26 September 2017
Ref: 5144

Re: Response to Draft Conditions - Modification MP 08_0167 MOD 3 at Belle O'Connor St, South West Rocks

Figure 8 – Revised Overall Staging Plan

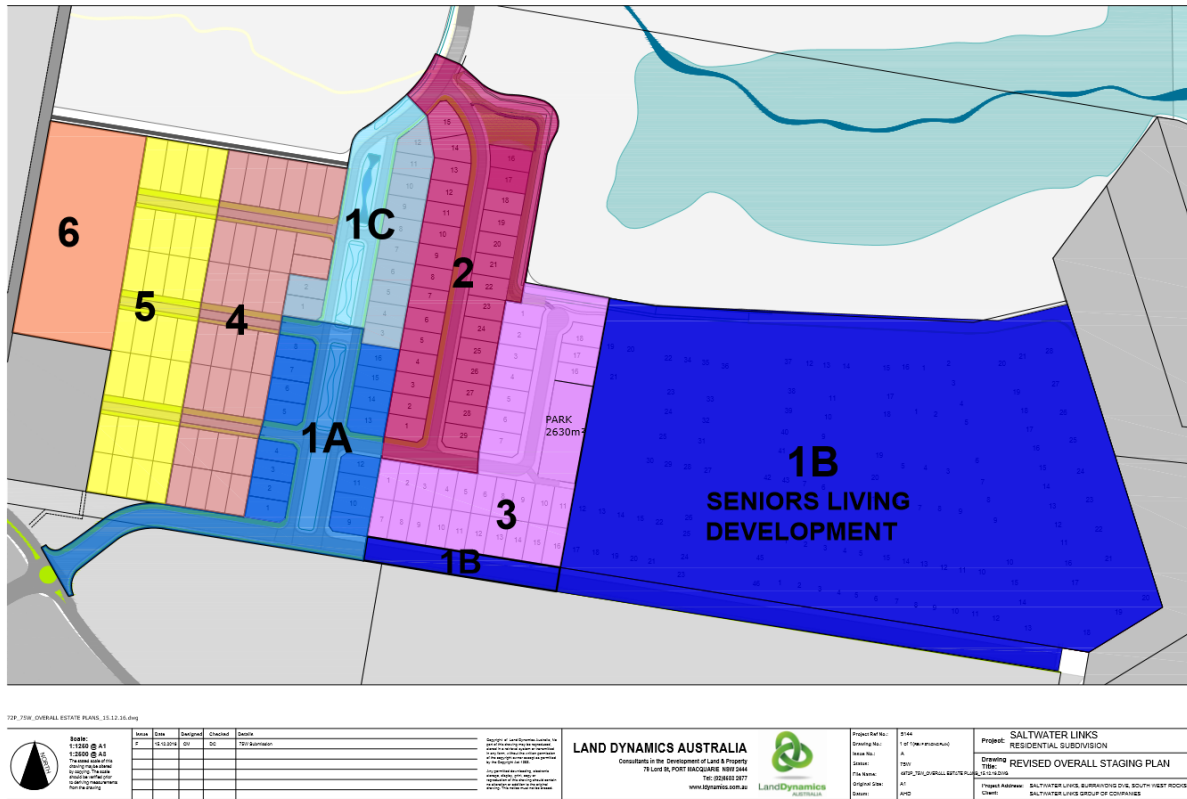
• The proposed overall staging plan shows that the whole of the seniors living development is Stage 1B to follow Stage 1A of 16 residential lots. This would result in Belle O'Connor Street being the only vehicular access for 250 lots 215 which is only marginally less than the existing approval for the 273 lot subdivision. Given that there would then be a further 131 lots to be created it is considered that this extends the overall development substantially beyond the previous Traffic Impact Assessment and therefore a further Assessment is required.

The currently proposed staging of this development would result in a significant delay in the creation of the north/south link.

Therefore, one of the following alternatives is required:

1. The staging of the Seniors Living is revised so that only Stages 1 and 2 of it are developed initially as Stage 1B and these are followed by Stages 1C and 2 of the residential subdivision. This would then create the necessary southern portion of the Link Road and the remaining Stages 3 to 12 could proceed.
2. As part of Stage 1A of the residential subdivision, which is currently underway, the Link Road corridor in Stages 1C and 2 is either transferred to Council or otherwise reserved in some fashion to ensure that this section of the Link Road can be constructed when required.

Stages 1A and 1B are proposed to occur separately but concurrently. Given the size of Stage 1B, it is likely that it will continue for many years and Stages 1C and subsequent SL stages would occur whilst the internal staging of 1B continues.

The statement by Council in the first paragraph is incorrect with respect to density and timing. Stage 1A has 16 residential lots and Stage SL1 of the Seniors Living has only 25 dwelling sites, being a total of 41 initial dwellings. Following this, Stage 1C and Stage SL2 of the Seniors Living will commence bringing around 12 residential lots and 20 dwelling sites, to be a total of 73 dwellings. Then Stage 2 will commence and Stage SL3 of the Seniors Living, bringing 25 residential lots and 21 dwelling sites, to be a total of 119 dwellings. At this point the north-south road access is accessible if required.

Council cannot dictate the timing of the road construction, which is subject to many factors which affect timing including commercial viability of the project. This road will be built in accordance with the current consent, which showed it being completed in Stage 2. Alternatively, Council could compulsorily acquire the land. Refer also to comments under draft conditions.

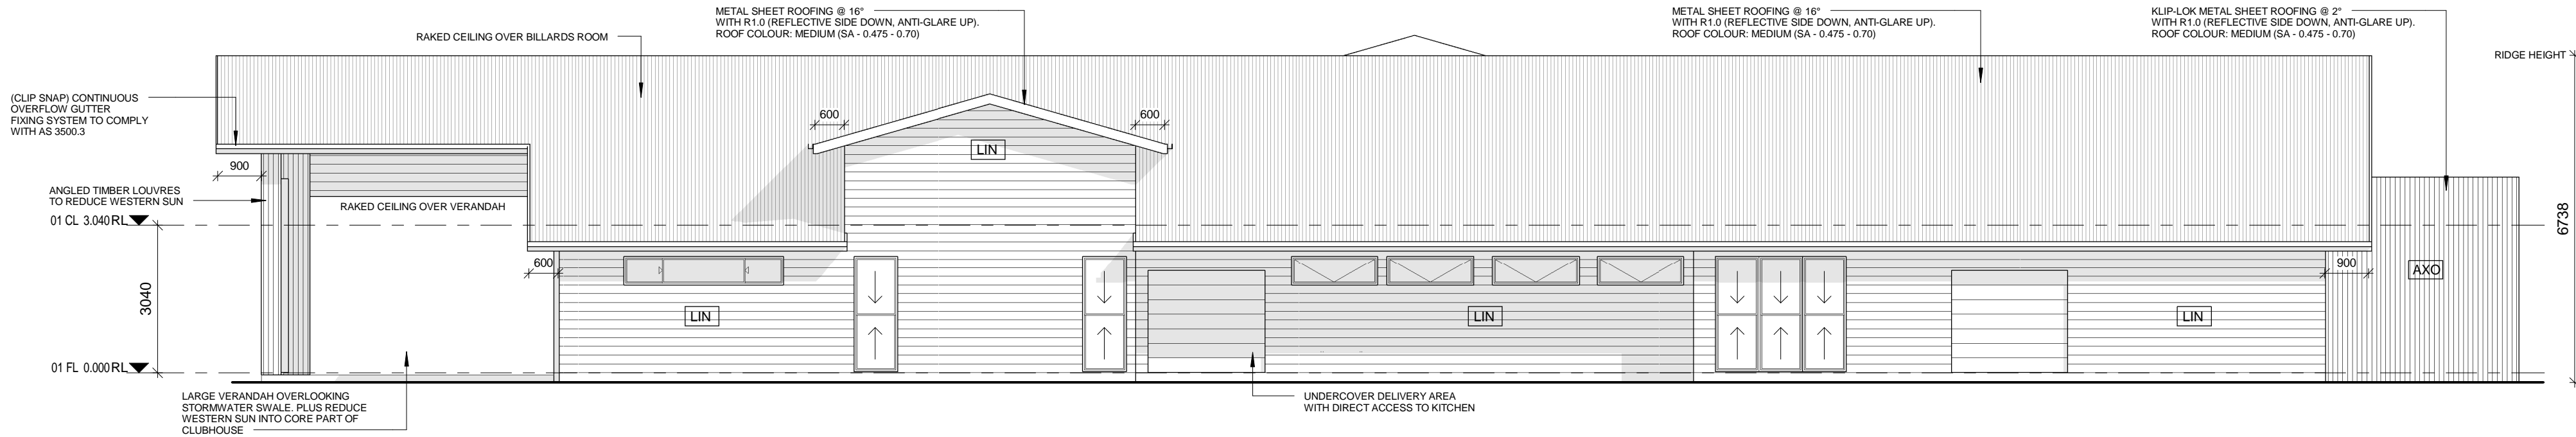
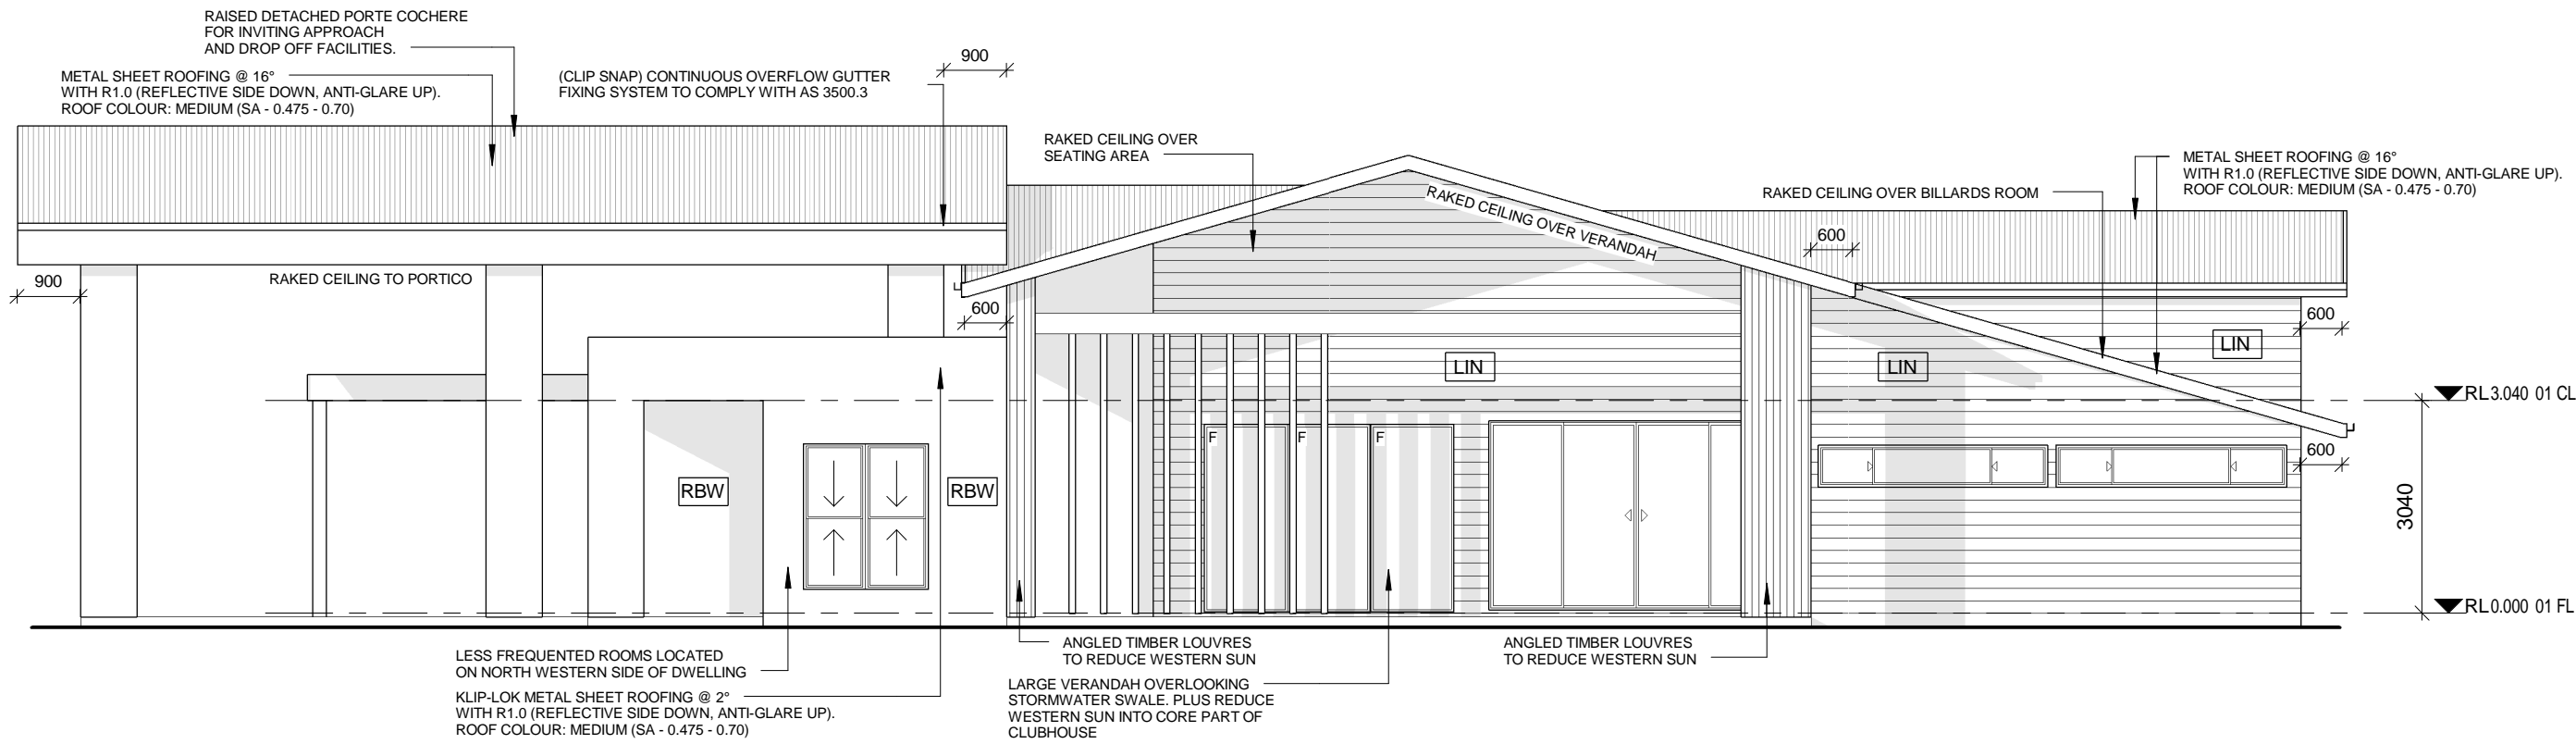
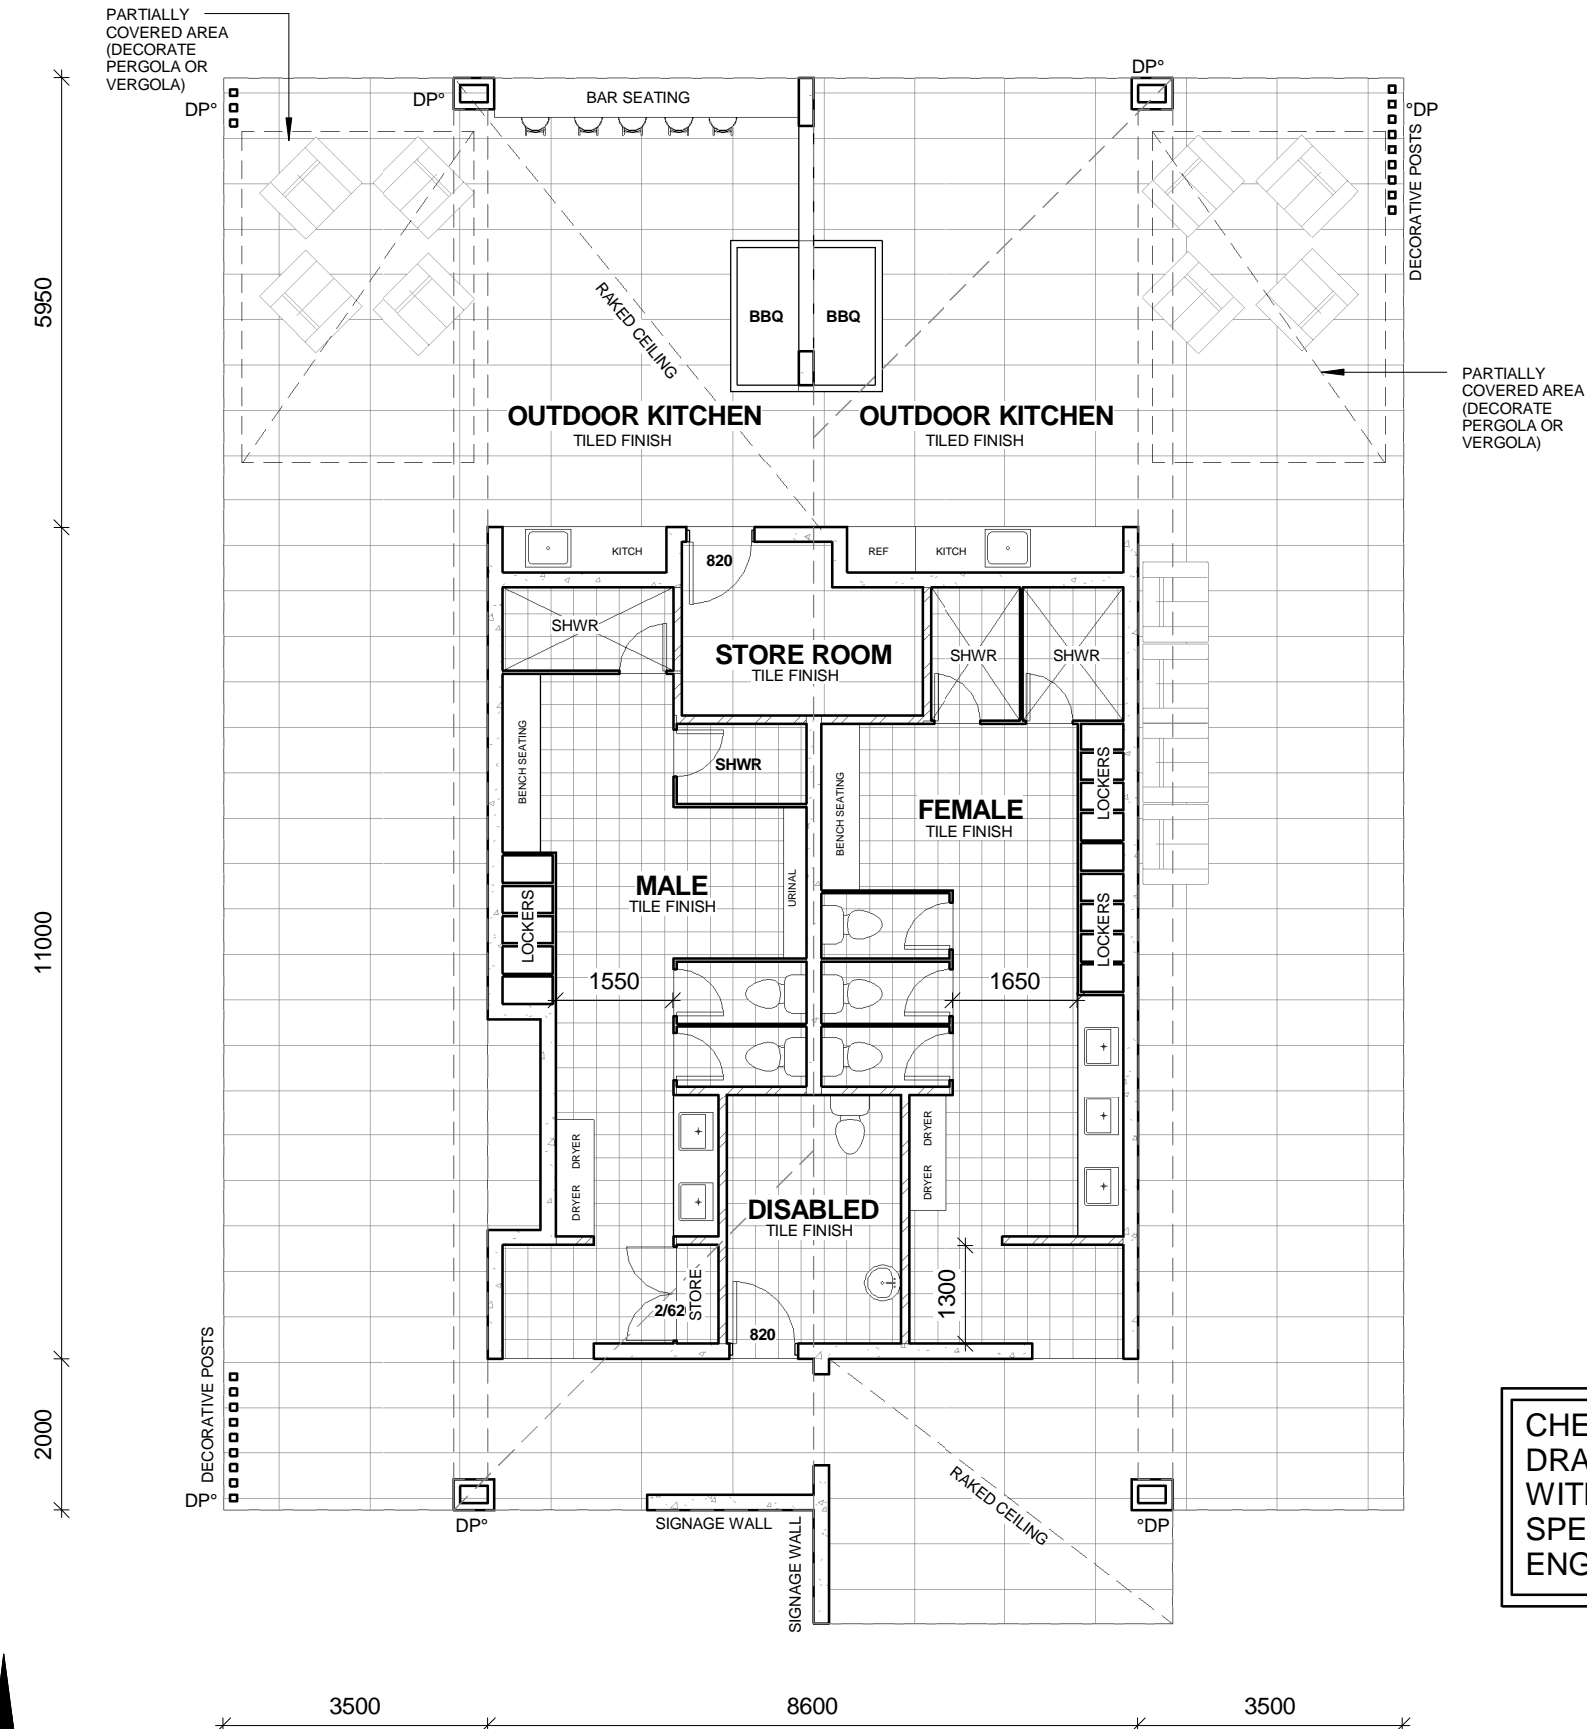
• The clubhouse concept plan shows a café, large main dining area (144 seats), theatre, computer/library, medical/doctor area, bar and games room. However, there is no discussion in the SEE of exactly what facilities/services are to be provided nor how, when and at what cost nor to whom.

In relation to the clubhouse, amenities and recreational facilities, will these be available only to the Seniors Living residents or to the wider community?

In relation to the proposed bar, is it intended to seek a liquor licence and will this be open to the wider community?

The senior's living development is in one ownership and the facilities will be provided and maintained by the owner at their expense. This is common practice for seniors living developments. The development is entirely private, with no SL roads, parks or facilities owned or managed by Council. The site has an on-site management team, supported by representatives of the residents.

The facilities will be available for use by the residents and their guests.

The proposed bar is a meeting area and it is unlikely that a liquor licence will be obtained. If in the future this is something that the residents wish to pursue, the process to obtain a liquor licence can be initiated at that time.
